From: Iqraa Malik
Sent: [REDACTED]
To: Sian Eggington
Subject: FW: Your ref - R/4/21/HH - Proposed Ground floor single storey rear extension and front porch - 36 Hawke Close Rustington BN16 2AT
Attachments: We sent you safe versions of your files; 36HC P-203A.pdf; 36HC P-206A.pdf

From: [REDACTED]
Sent: [REDACTED]
To: Iqraa Malik
Cc: [REDACTED]
Subject: Your ref - R/4/21/HH - Proposed Ground floor single storey rear extension and front porch - 36 Hawke Close Rustington BN16 2AT

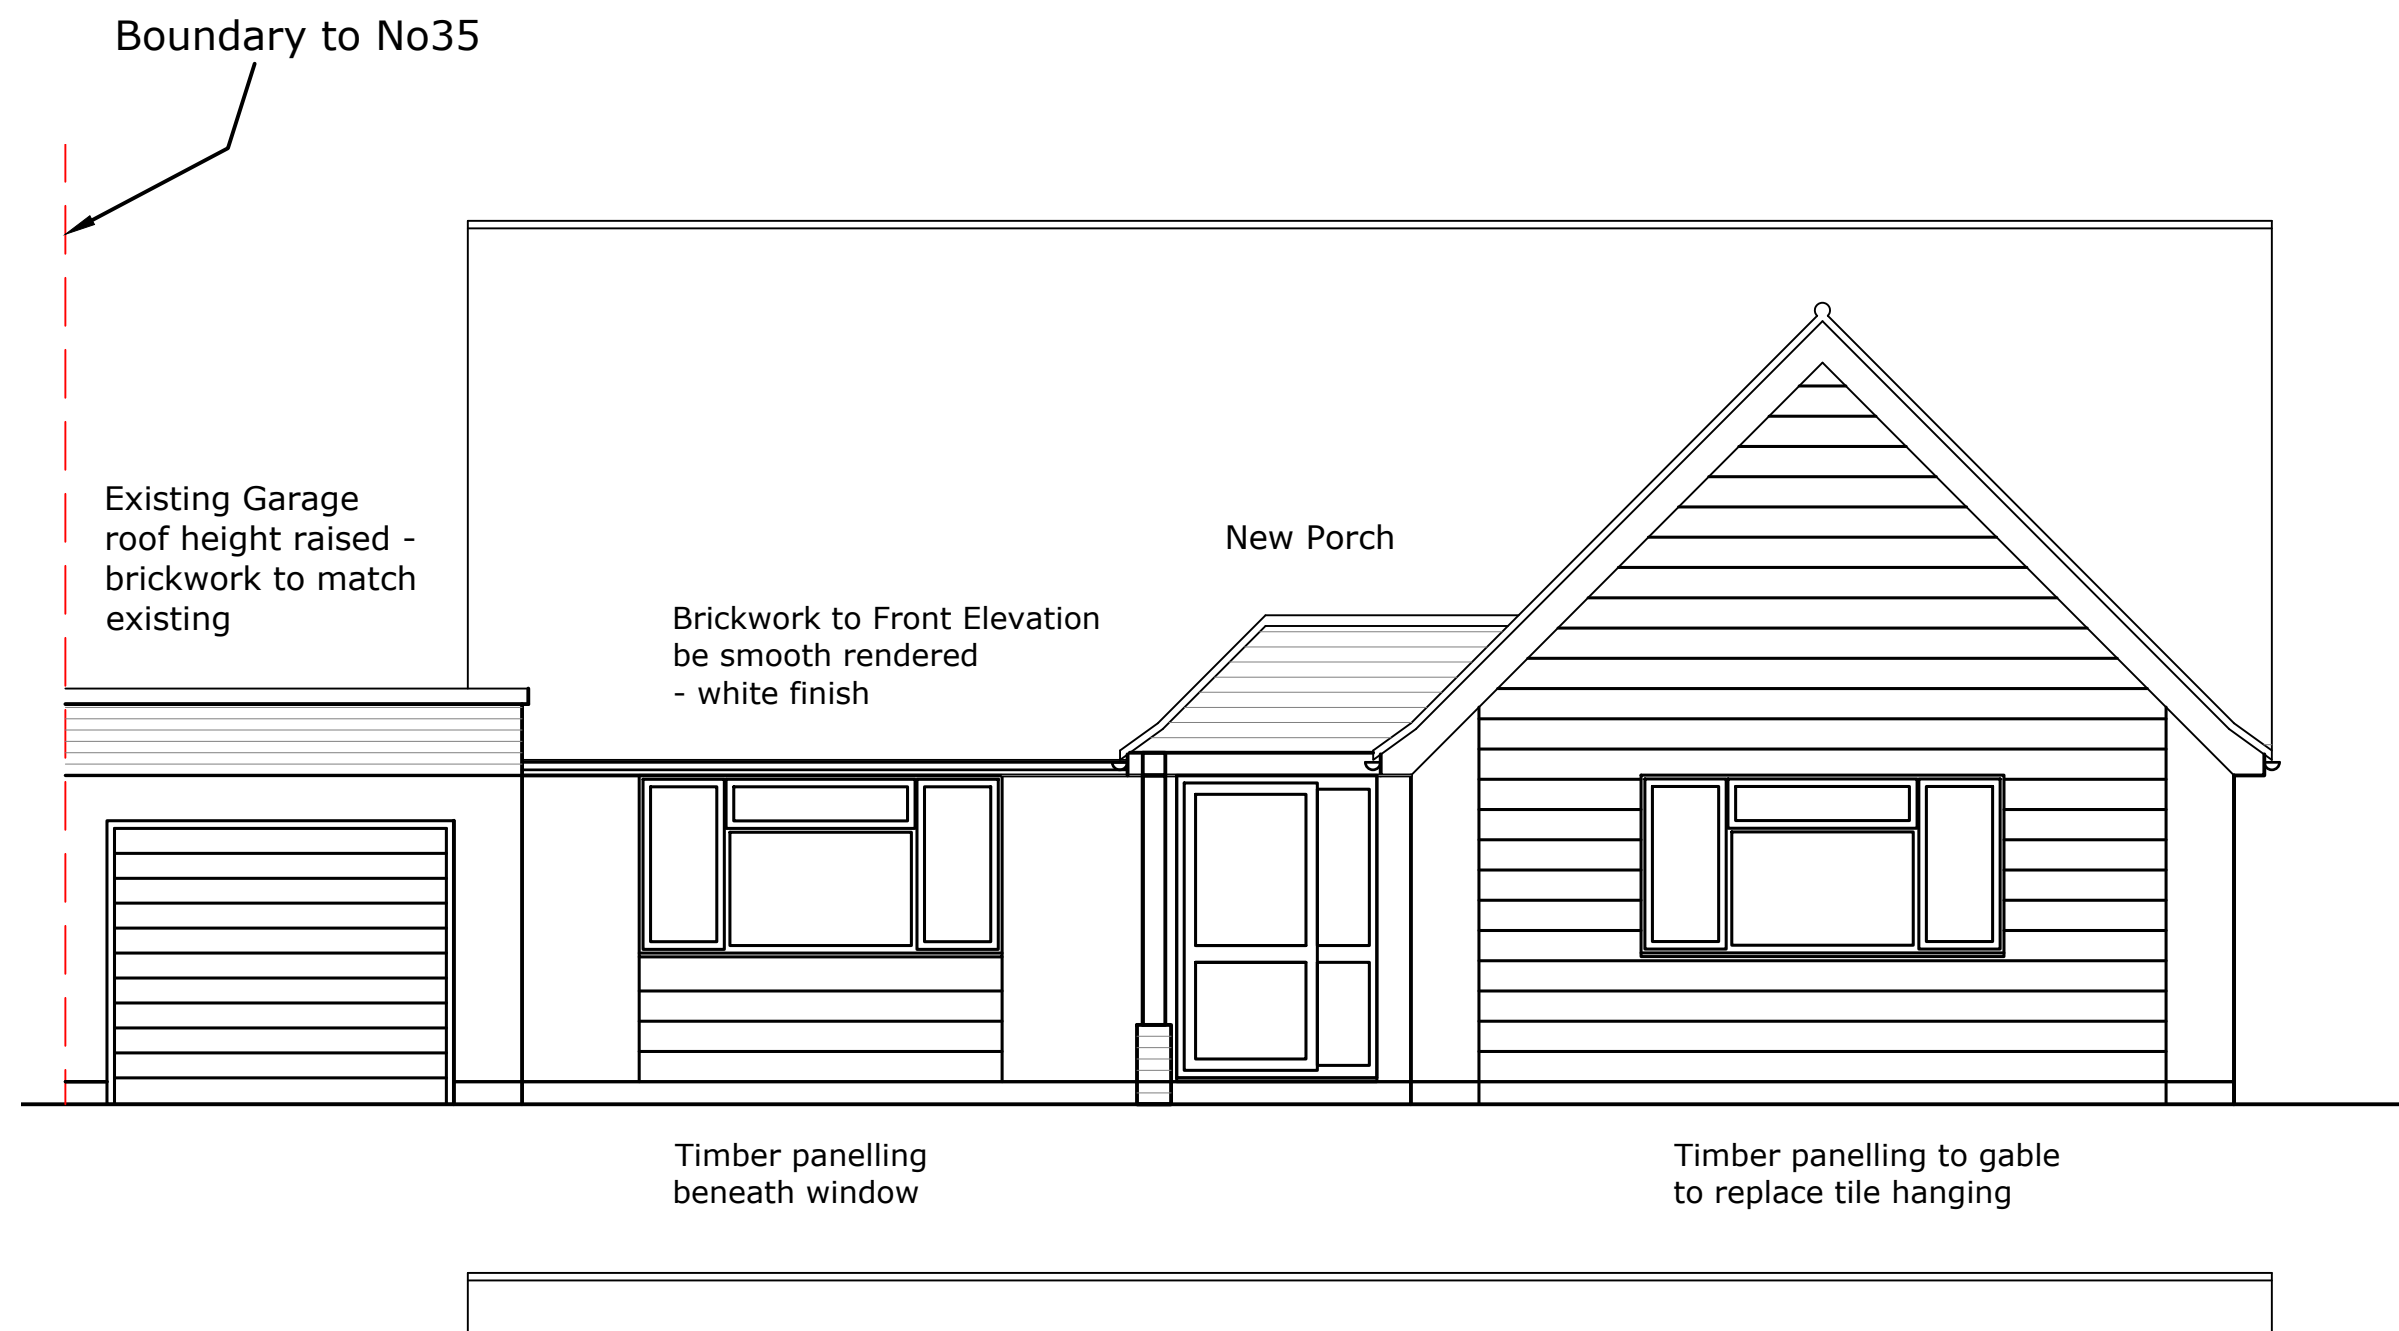
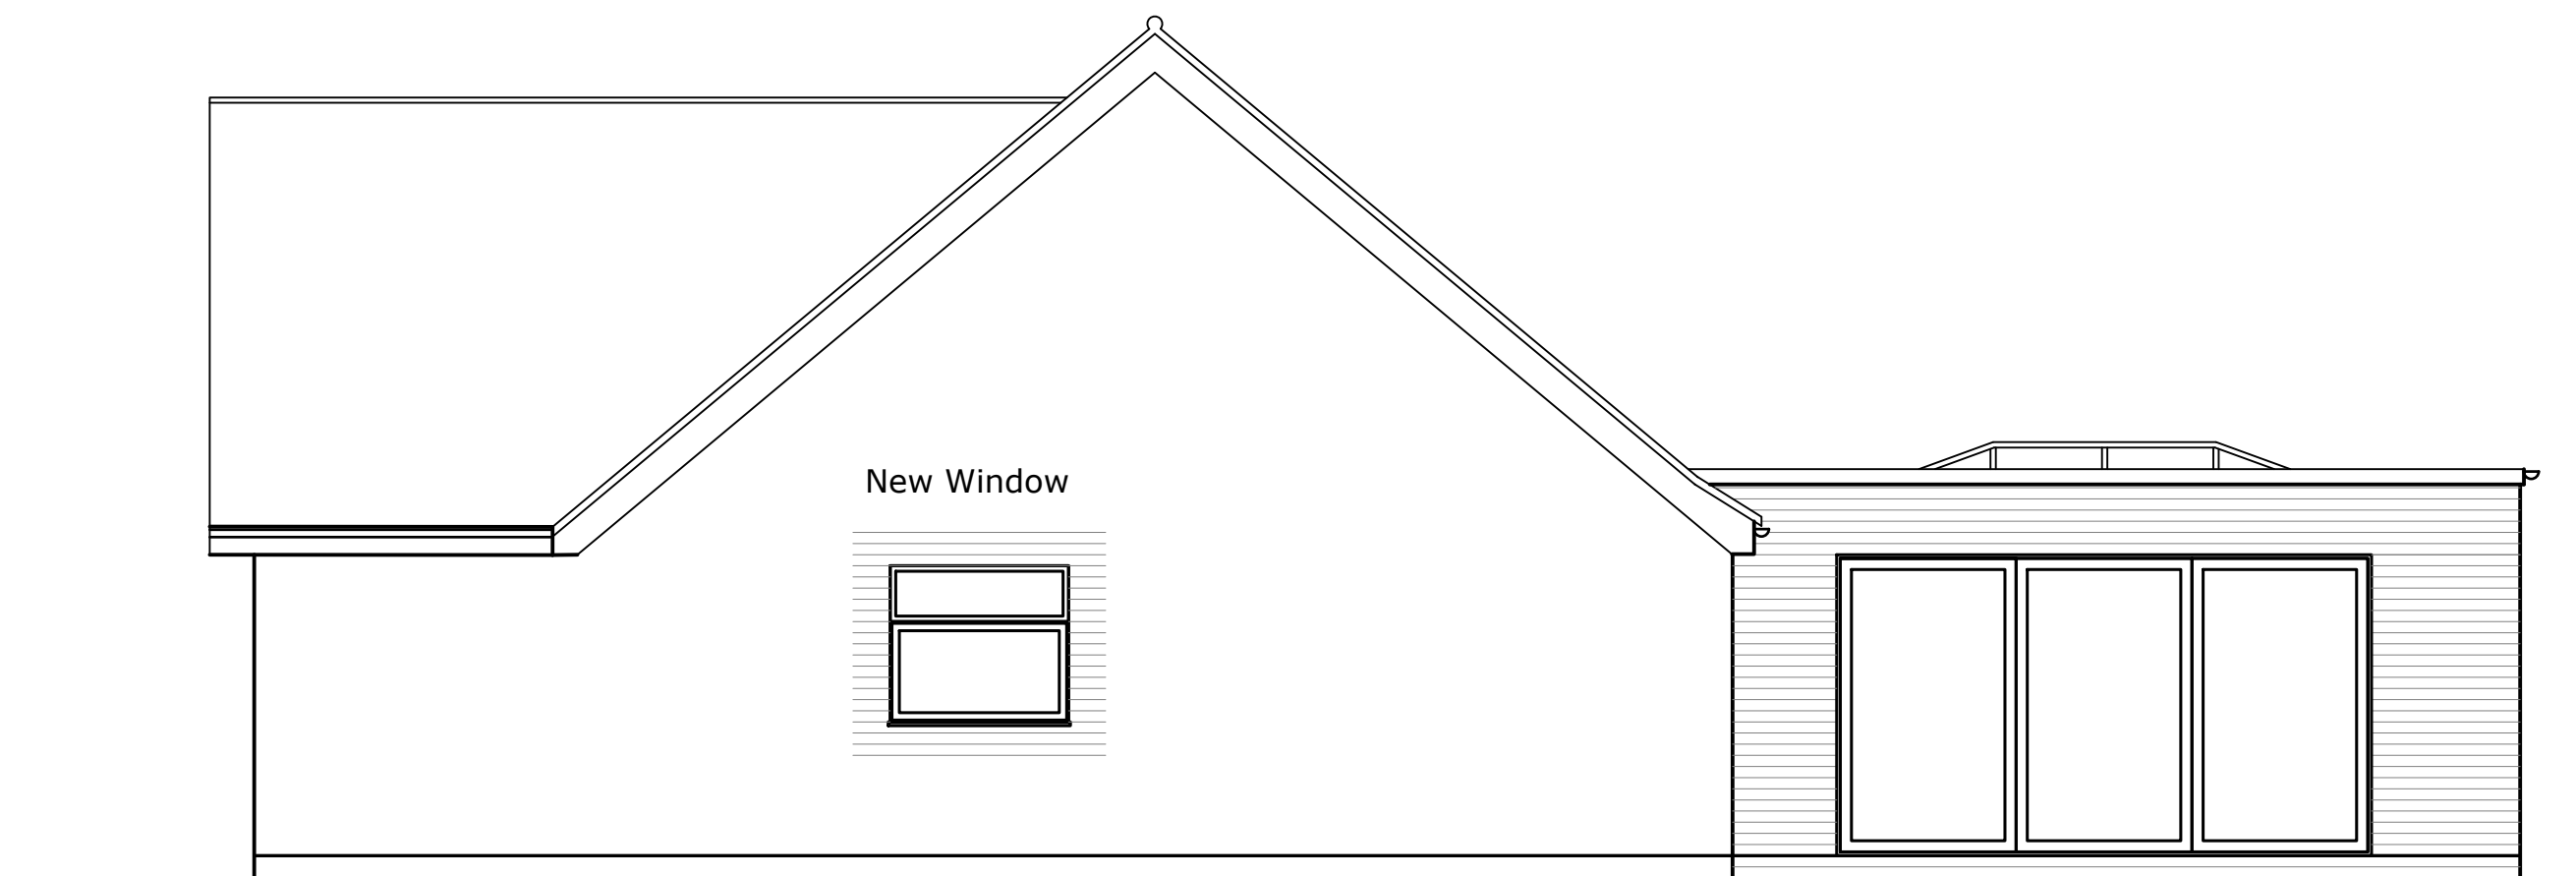
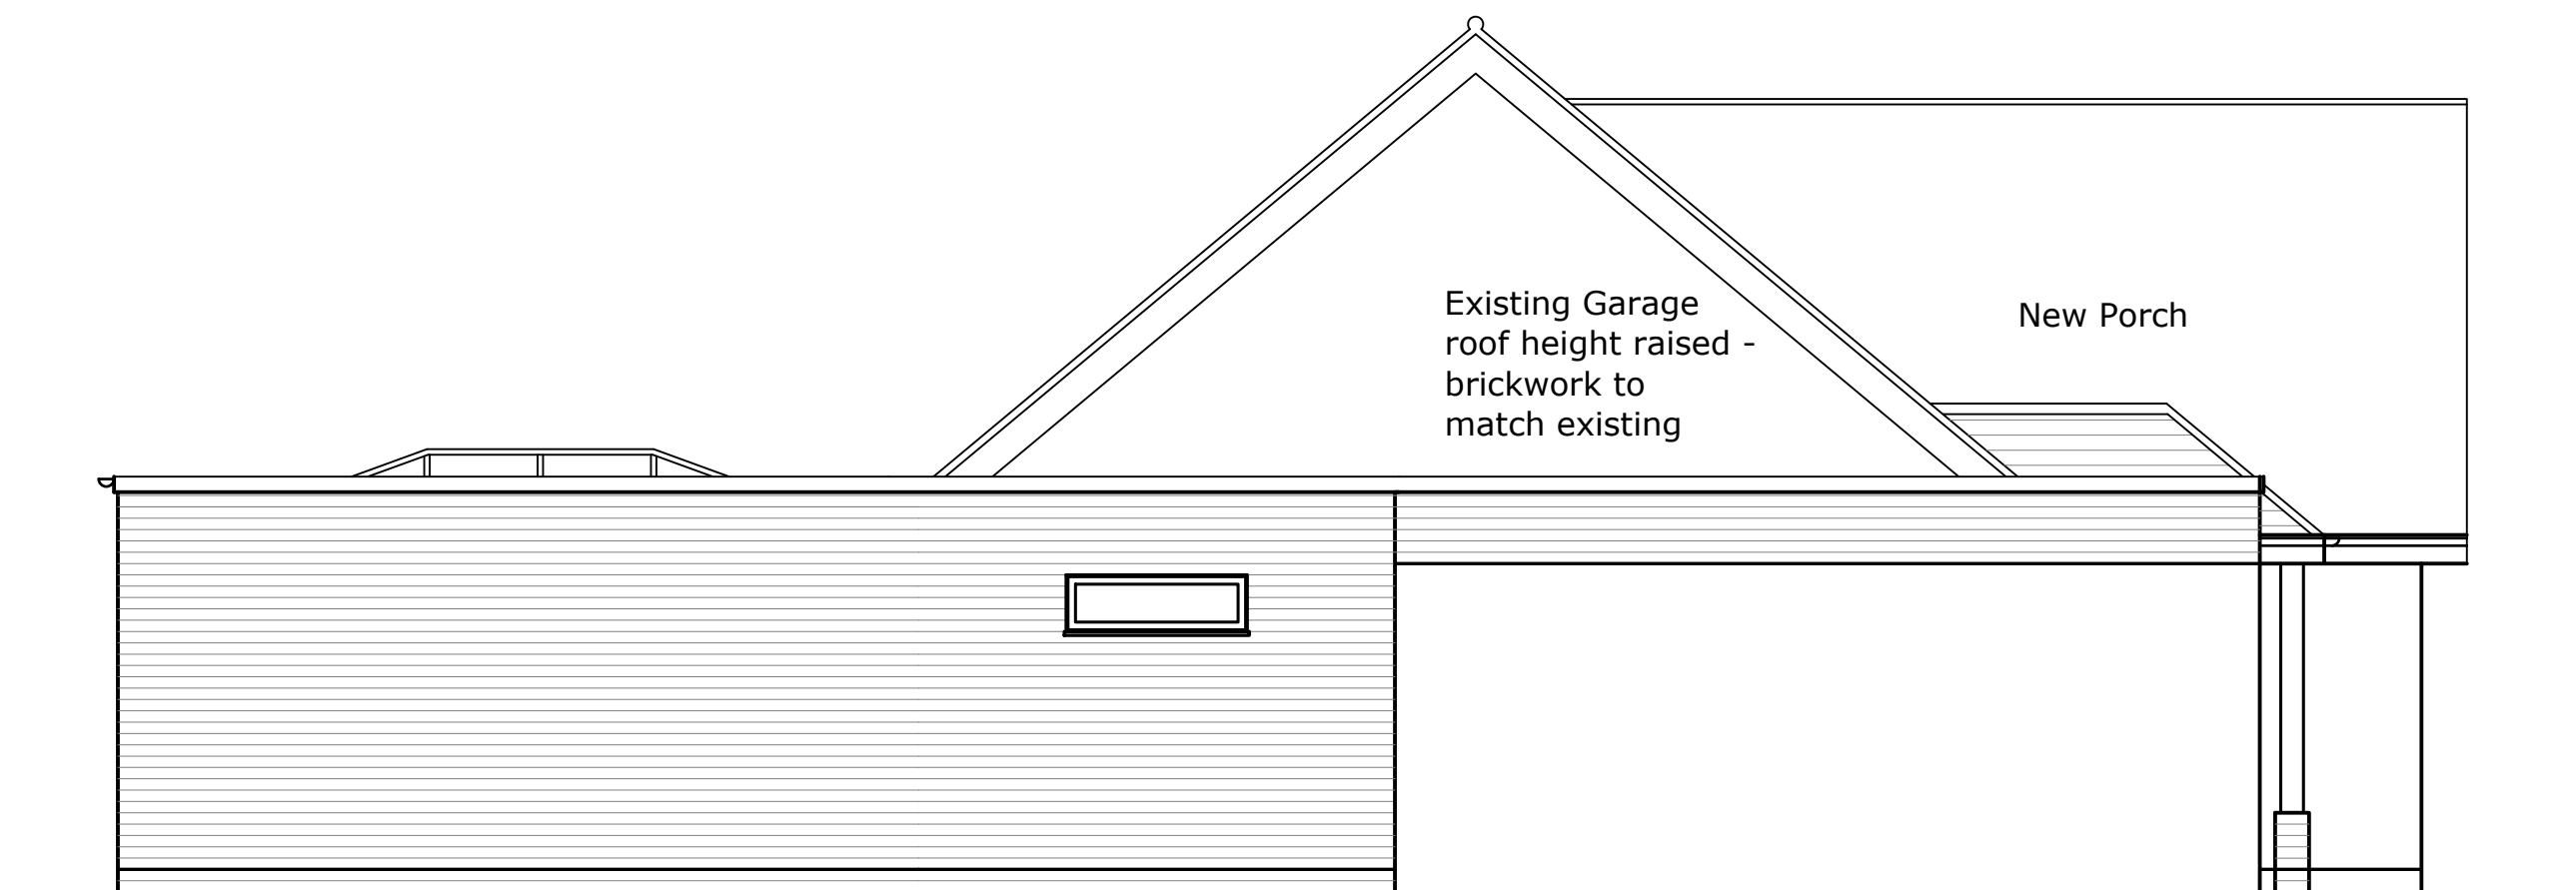
Please find attached a revised Block Plan showing dimensions from the proposed extension to the site boundaries. I recently rang your offices to advise that my Client now also wishes to raise the roof height of the existing garage with brickwork to match existing.

I hope that the revised drawing as attached to reflect this change can be included in the current application.
